Subject: SP-26-00005 Ridgway - Notice of Application

To: All Staff
From: Environmental Health
Date: 6/25/2026
Subject: SP-26-00005 Ridgeway

TO: All Staff
FROM: Public Works Plan Review Team
DATE: July 6, 2026
SUBJECT: SP-26-00005 Ridgway

# RIDGWAY SHORT PLAT PART OF SECTION 29, T. 18 N., R. 19 E., W.M. KITTITAS COUNTY, WASHINGTON

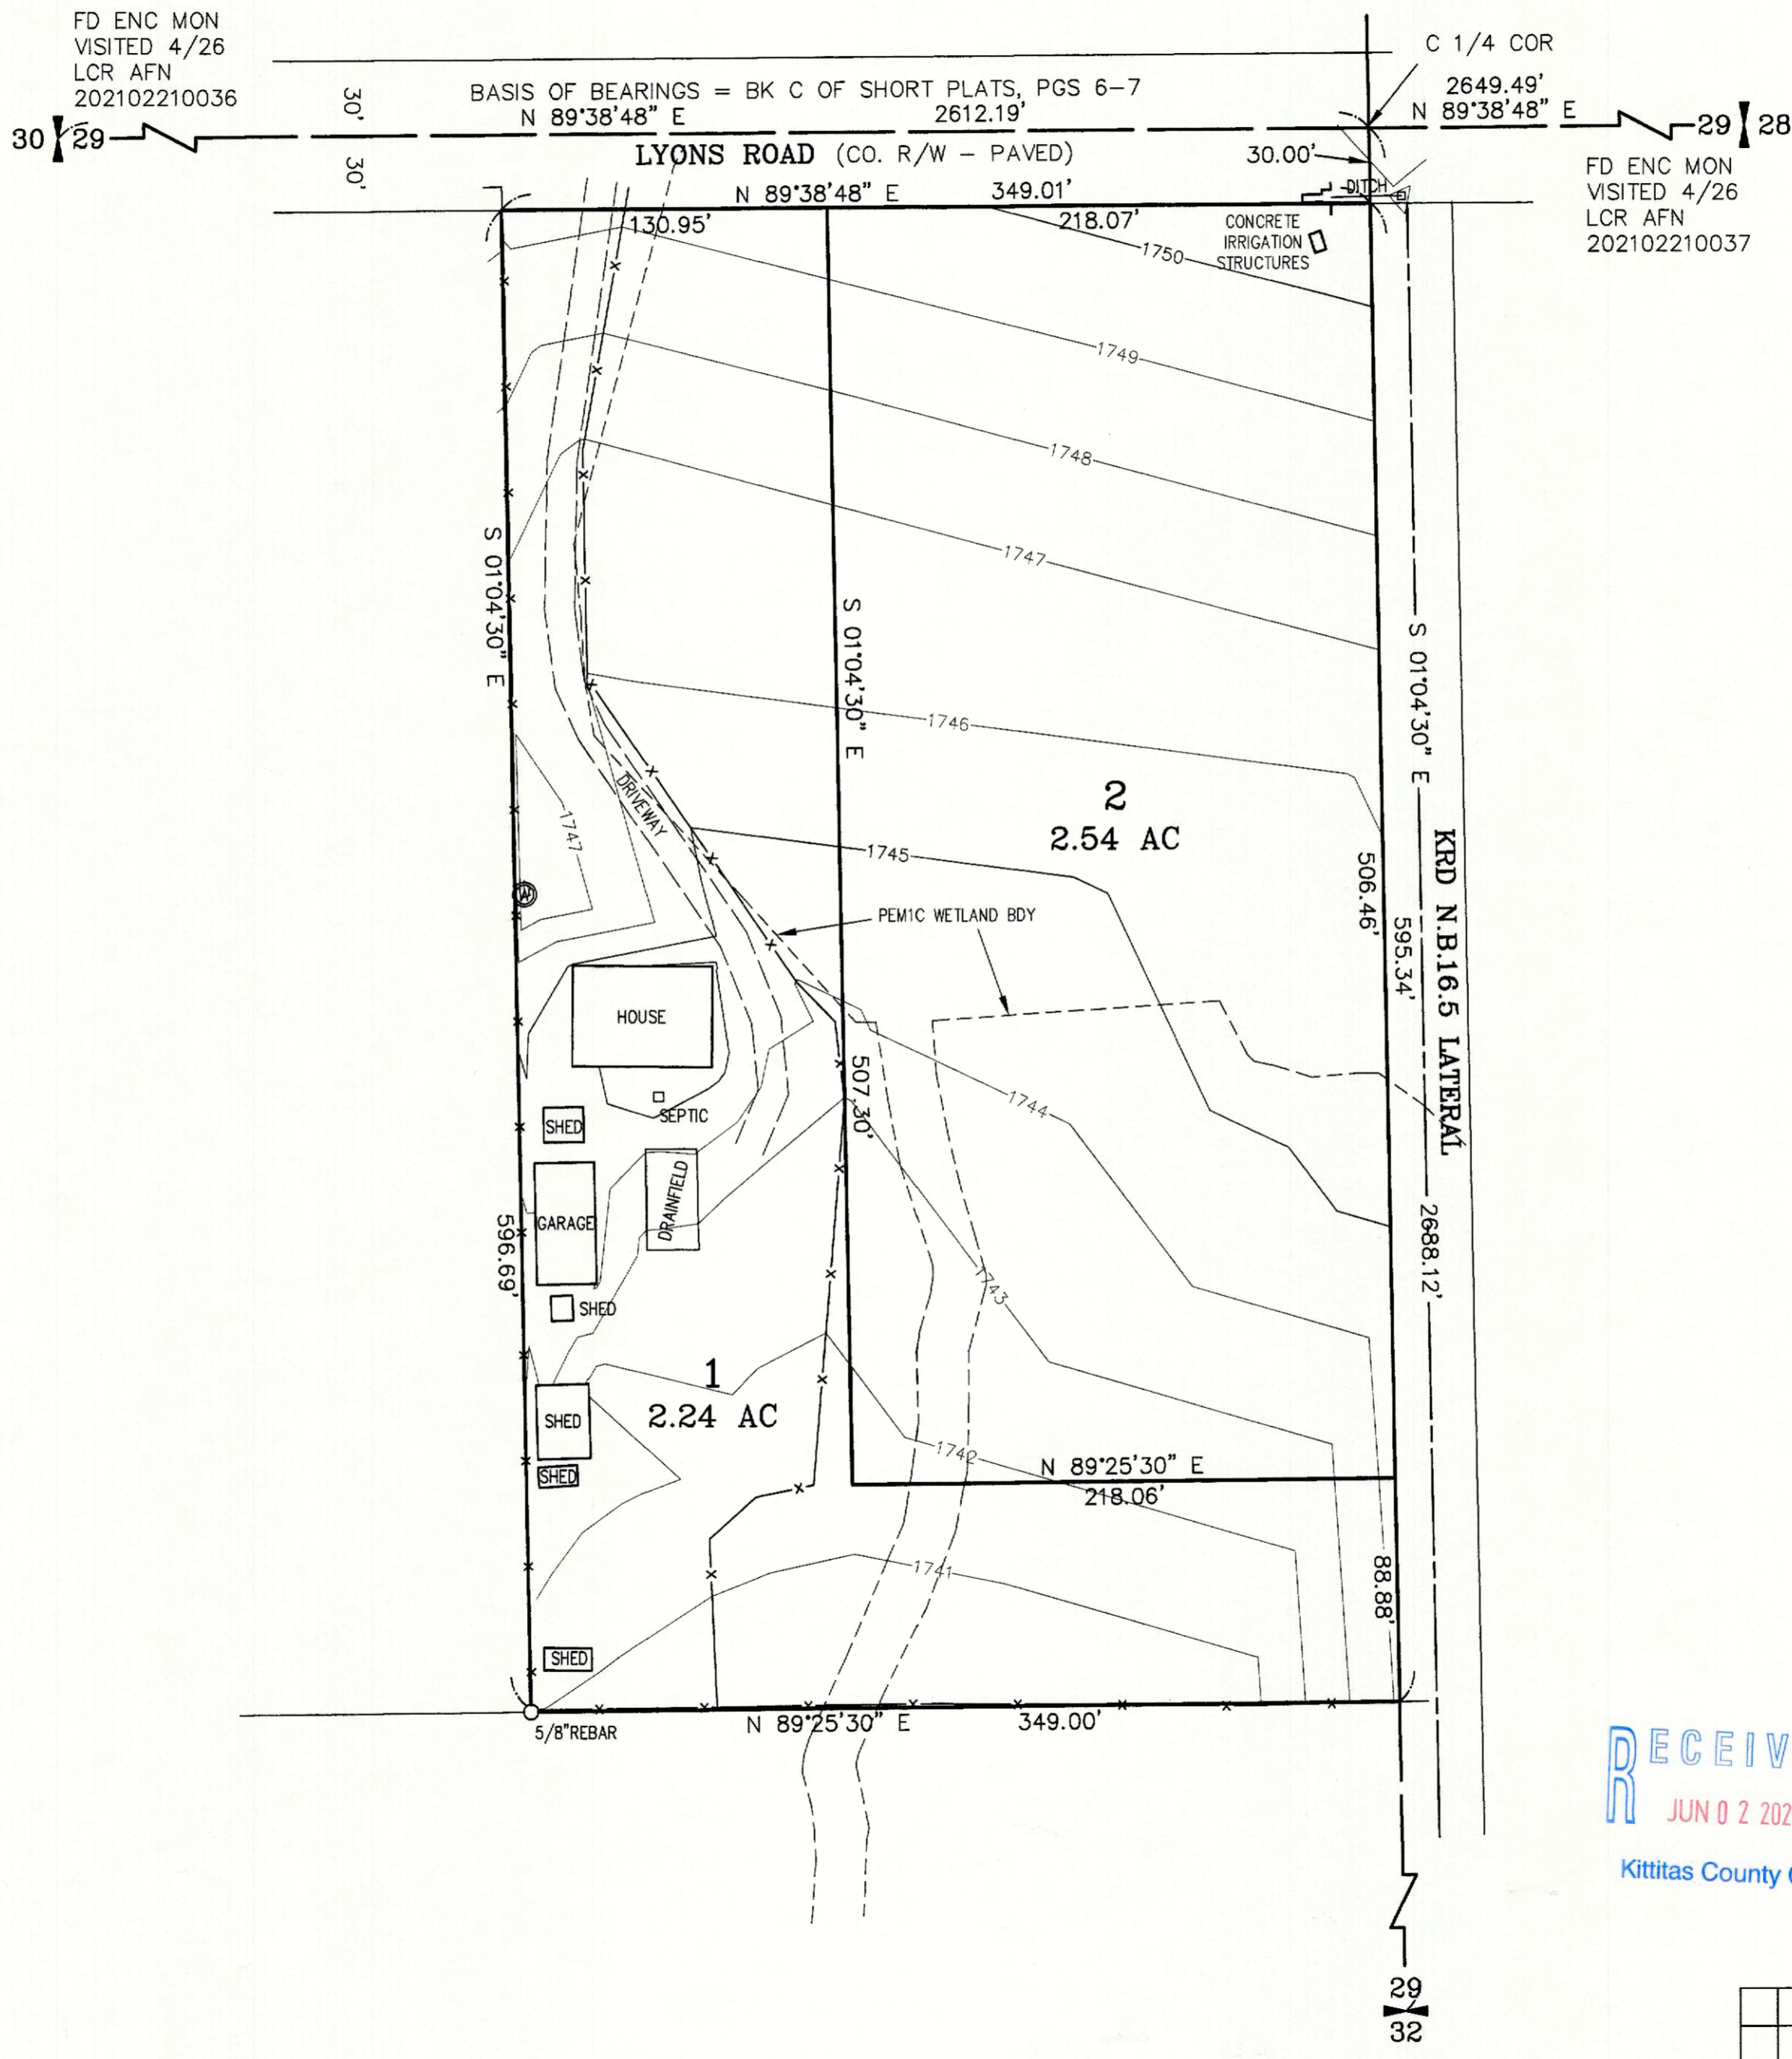
Wastewater	• Prior to preliminary plat approval, the applicant shall perform soil logs in accordance with KCC 13.08.040 to demonstrate that the proposed lots can support conforming on-site sewage systems and required reserve areas. The evaluation shall include a minimum of two soil test pits per lot within the primary and reserve drainfield areas, and the test pit locations shall be shown on the plat map and flagged in the field for inspection.

ENGINEERING	Except as exempted in KCC 14.05.060, no grading or filling upon a site involving more than one hundred (100) cubic yards shall be performed without a grading permit from the County Engineer or Public Works designee (KCC 14.05.050). An application for grading in excess of five hundred (500) cubic yards shall be accompanied by an engineered grading plan (KCC 14.05.080). (CBP)
SURVEY	1. Lot closures were not provided. Due to simple nature of division, Lot Closures are not required. 2. Title report not provided. Title report will need to be reviewed prior to final approval. This may trigger additional survey requirements. 3. There appear to be problems with the existing legal description. This will be reviewed when Title Report is received. Incorrectly labelled as 'Dedication'. 4. Note 3 needs recording information. 5. The S1/4 cor of Section shown is missing a label and description. 6. As a minimum, the new division line will need to have corners shown and set in the field. 7. Per aerial images, it appears that there may be usage/trespass along the east line of the subject property. This should be shown and noted.

8. The name of the Short Plat must be unique. 9. Include building offsets from property lines. (JT)
TRANSPORTATION CONCURRENCY	Not required for this project. (RC)
FLOOD	Parcel # 636636 is not mapped within a FEMA identified special flood hazard area (1% annual chance flood zone). Floodplain development permitting is not required for the proposed project. (SC)
WATER MITIGATION/ METERING	The following comments outline the requirements for legal availability of water and metering for the proposed short plat: The applicant must provide legal water availability for all new uses on the proposed lots of this project. Prior to final plat approval and recording, the following conditions shall be met: In accordance with KCC Chapter 13.35.027, the applicant shall provide one of the following documents before final plat approval: 1. A letter from a water purveyor stating that the purveyor has adequate water rights and will provide the necessary water for the new use; 2. An adequate water right for the proposed new use; or 3. A certificate of water budget neutrality from the Department of Ecology or other adequate interest in water rights from a water bank. All applicants for land divisions shall also submit information on "proximate parcels" held in "common ownership" as those terms are defined in WAC 173-539A-030 and otherwise demonstrate how the proposed new use will not violate RCW 90.44.050 as currently existing or hereafter amended. Failure to obtain mitigation before commencement of an activity requiring mitigation shall be a code violation subject to enforcement under Title 18 KCC. Final Plat Notes The following notes shall be placed on the face of the plat: C-1 "Metering is required for all new uses of domestic water for residential well connections and usage must be recorded in a manner consistent with Kittitas County Code Chapter 13.35.027 and Ecology regulations." C-2 "The approval of this division of land provides no guarantee that use of water under the ground water exemption (RCW 90.44.050) for this plat or
